THE ABLE MARINE ENERGY PARK DEVELOPMENT CONSENT ORDER

TR030001

Comments on Responses to the First Round of Written Questions

Harbour Master, Humber

Figure N1.9 Proposed disposal sites in the Humber Estuary (©OS OpenData™),)

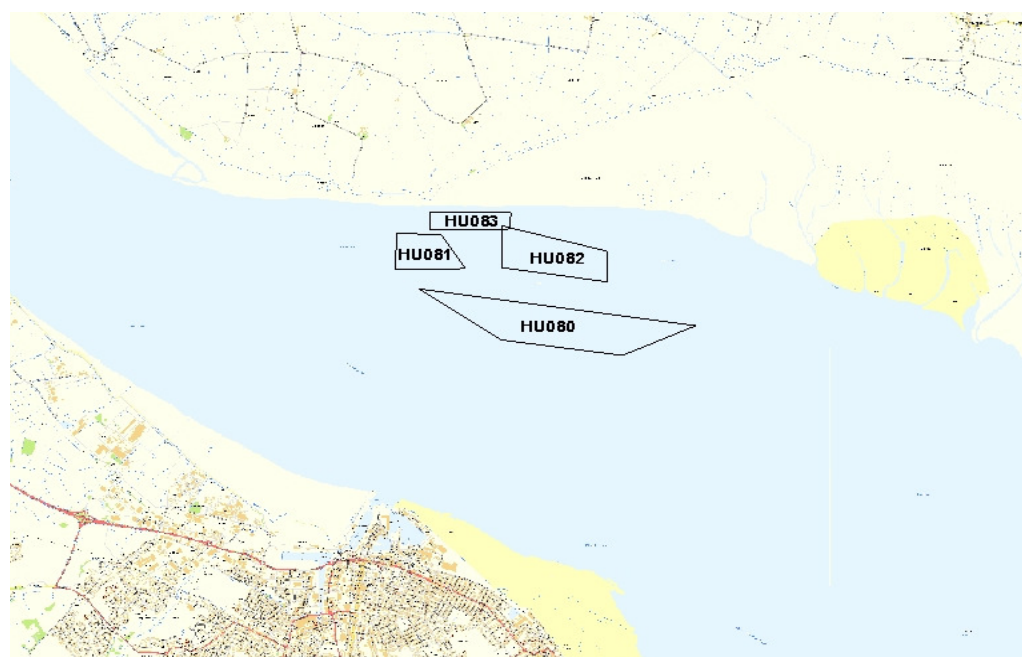
Able – Marine Matters - Q. 39 – disposal of non-erodible material at HU082 & Q. 40 disposal of erodible material at HU080

17. Able's response to Q. 39 fails to mention the regulatory functions of the MMO under the dredging conditions in the deemed marine licence in Schedule 8 to the DCO and of the Harbour Master, Humber under paragraph 10 of Part 2 of Schedule 9. The latter would require Able to obtain prior consent to its proposals for disposal of both erodible and non-erodible material. In addition, the amended paragraph 8 would ensure that there could not be any conflict between himself and the MMO as regards the various submissions to the MMO that Able would be required to make.
